# **KIRKLEES METROPOLITAN COUNCIL INVESTMENT & REGENERATION SERVICE**

**DELEGATED DECISION TO DETERMINE PLANNING APPLICATIONS**

| Reference No:         | <b>2025/62/93551/E</b>                                       |
| Site Address:         | 17, Warren Street, Savile Town, Dewsbury, WF12 9LU           |

| DRAWING TITLE<br>Proposed Floor Plans & Elevations           |                     | DRAWN BY/ CHECKED BY<br>MR/FY |                    |

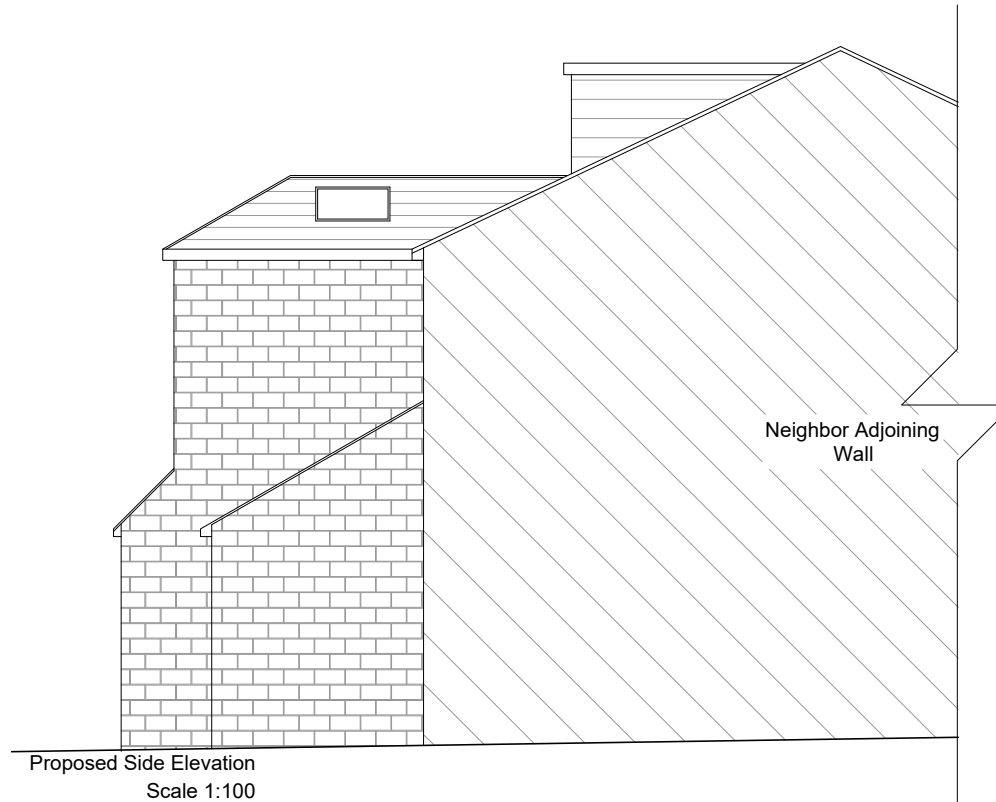
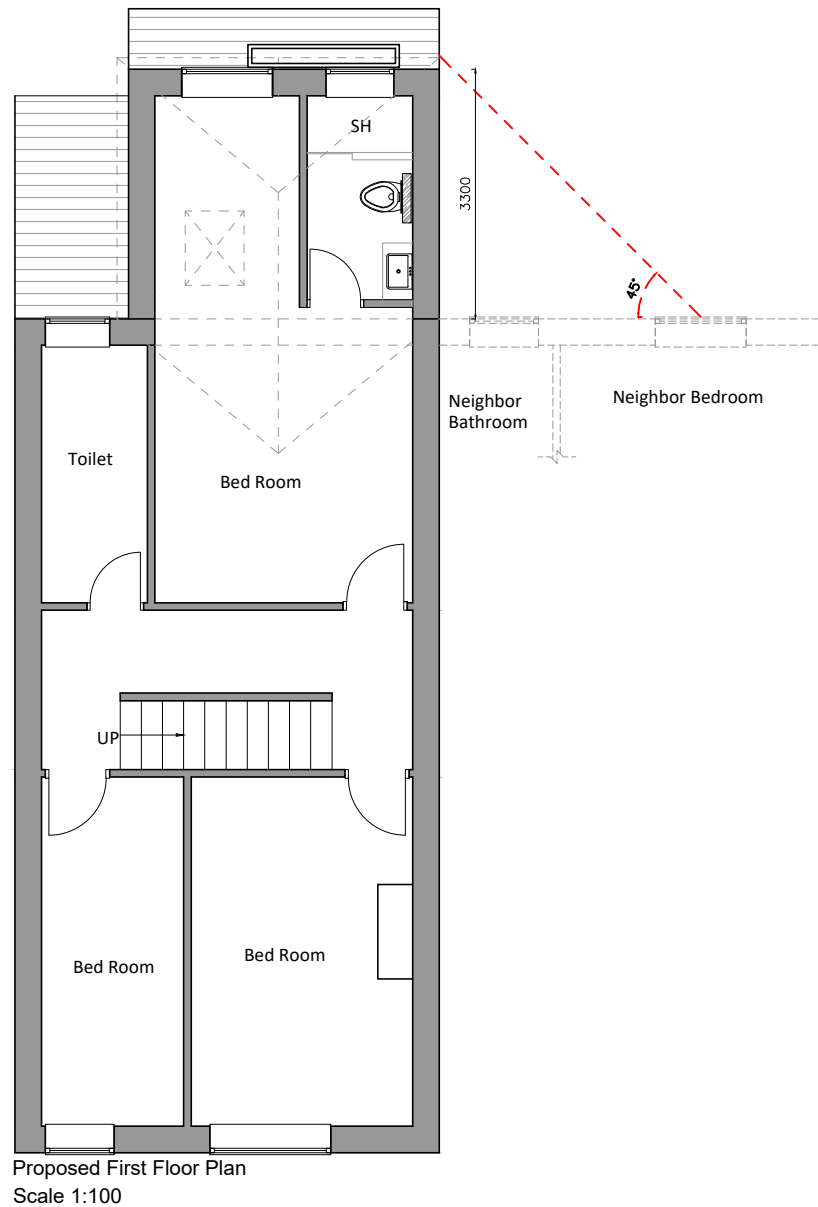
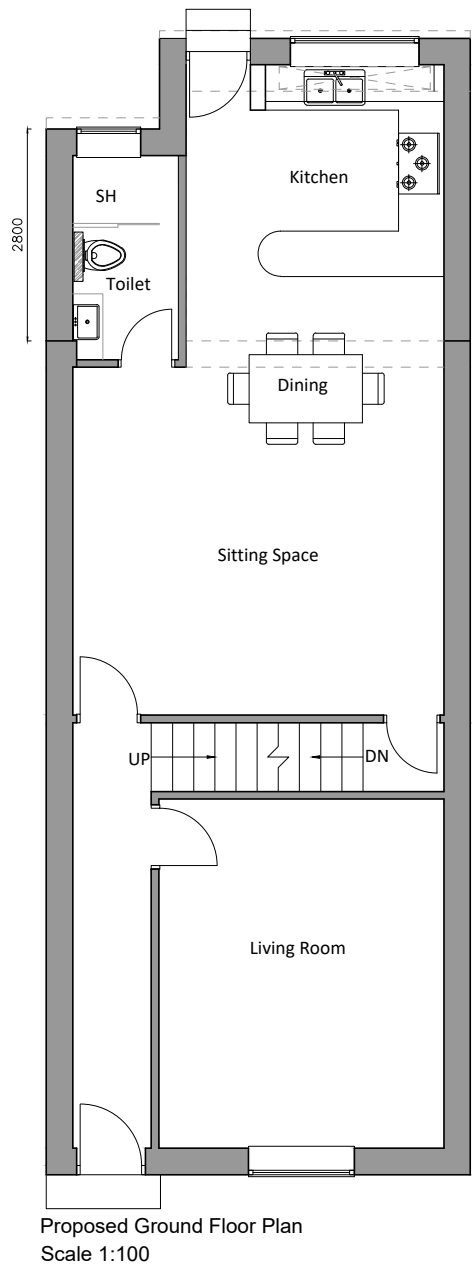
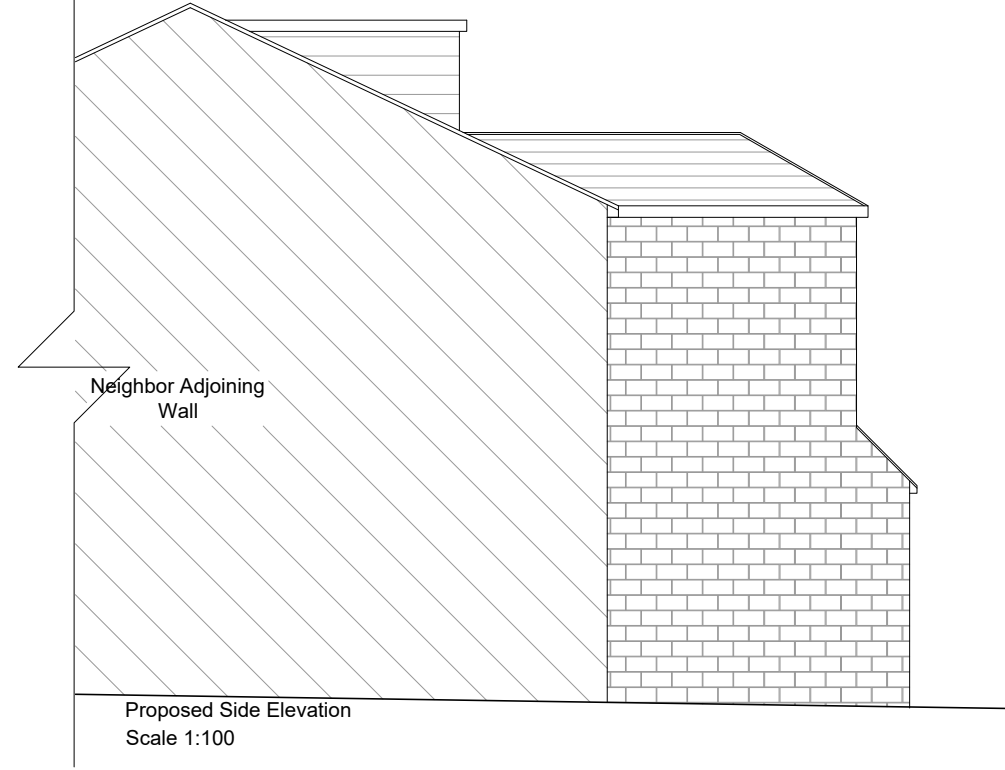
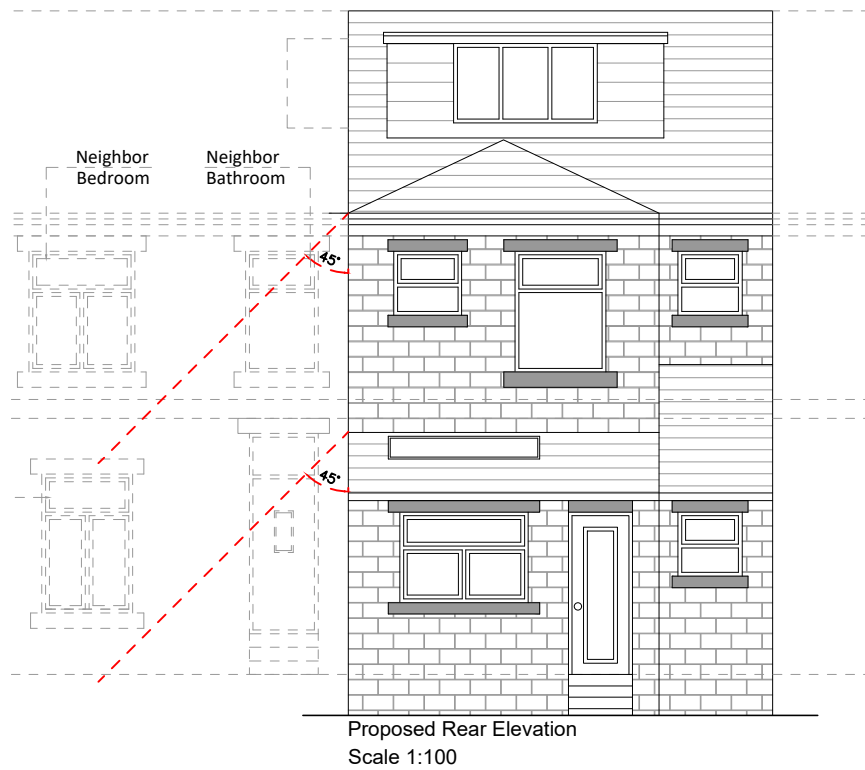
Amended plans were sought and received which reduced the projection and which removed the first floor balcony element. The amended plans indicate the 45 degree relationship an neighbouring property. Reductions were requested in terms of the impact on the adjoining 15 Warren Street and the balcony element was removed and the ground floor set back.

The proposed extension is not considered to result in an unacceptable impact on the residential amenity of the adjoining neighbour to the west. Whilst the development would project up to 4.1m at ground floor level, reducing to 3.3m at first floor, the plans have been amended to remove the initially proposed

balcony so that the first floor is inset from the shared boundary by 1.5m and the ground floor has been reduced for the same area to a projection of 2.8m. It is noted that this neighbour has already constructed a substantial rear extension measuring approximately 4.9m in depth, set off the shared boundary and that there is a ground floor window in the original house and on the side elevation of the neighbour's extension which will be impacted to a degree.

However, it is concluded that the amended scheme has sought to reduce the development proposal in terms of size / scale in proximity to no.15 which reduces the perceived sense of enclosure and overbearing impact. It is noted the extent of the single storey element in proximity of this property has a projection which could be undertaken through utilisation of pd rights. Notwithstanding this point it is considered that the extent of the impact of the proposal, having regard to existing developments undertaken at no.15 and the extent of amendments set out in the submitted plans, is such that it is concluded the proposal would be acceptable in this case.

The proposed extension is not considered to give rise to an unacceptable impact on the residential amenity of the adjoining neighbour to the east. Whilst this neighbouring property does not benefit from any existing extensions, the proposal has been designed to minimise harm, projecting 4m at ground floor level and stepping back to 3.3m at first floor. This reduction in depth at first floor assists in lessening any potential overbearing or overshadowing effects when viewed from the neighbouring property. Moreover, the only first floor window positioned closest to the shared boundary would serve a bathroom, which is typically obscurely glazed and non-opening or top-hung, thereby preventing opportunities for overlooking. On this basis, it is considered that the proposal would not result in any material loss of privacy, light, or outlook, and would maintain an acceptable level of residential amenity for the adjoining occupier.

**Response** – *In terms of the impact on the adjoining no. 15. Amendments, including removal of the balcony, a 1.5m first-floor setback, and reduction of the ground-floor projection to 2.8m, lessen impacts. While some neighbouring windows may be affected, the changes reduce the sense of enclosure or overbearing effect. And with regards to the adjoining no. 19 Although the property has no existing extensions, the design limits impact by projecting 4m at ground floor and stepping back to 3.3m at first floor, reducing overbearing and overshadowing effects. The nearest first-floor window would serve a bathroom and be obscurely glazed, preventing overlooking. Overall, no significant loss of privacy, light, or outlook is considered to arise in this case given the revisions to the scheme.*

**Response** *For No. 15, the amended design—including removal of the balcony, a 1.5m first-floor setback, and reduction of the ground-floor projection to 2.8m—serves to limit overshadowing. While there may be some impact on neighbouring windows, the revisions reduce the degree of light loss and soften the overall effect.*

*For No. 19, overshadowing is mitigated through the stepped design, with a 4m ground-floor projection reducing to 3.3m at first floor. This approach lessens potential loss of daylight and sunlight to the neighbouring property. Overall, the proposal is not considered to result in significant overshadowing impacts.*
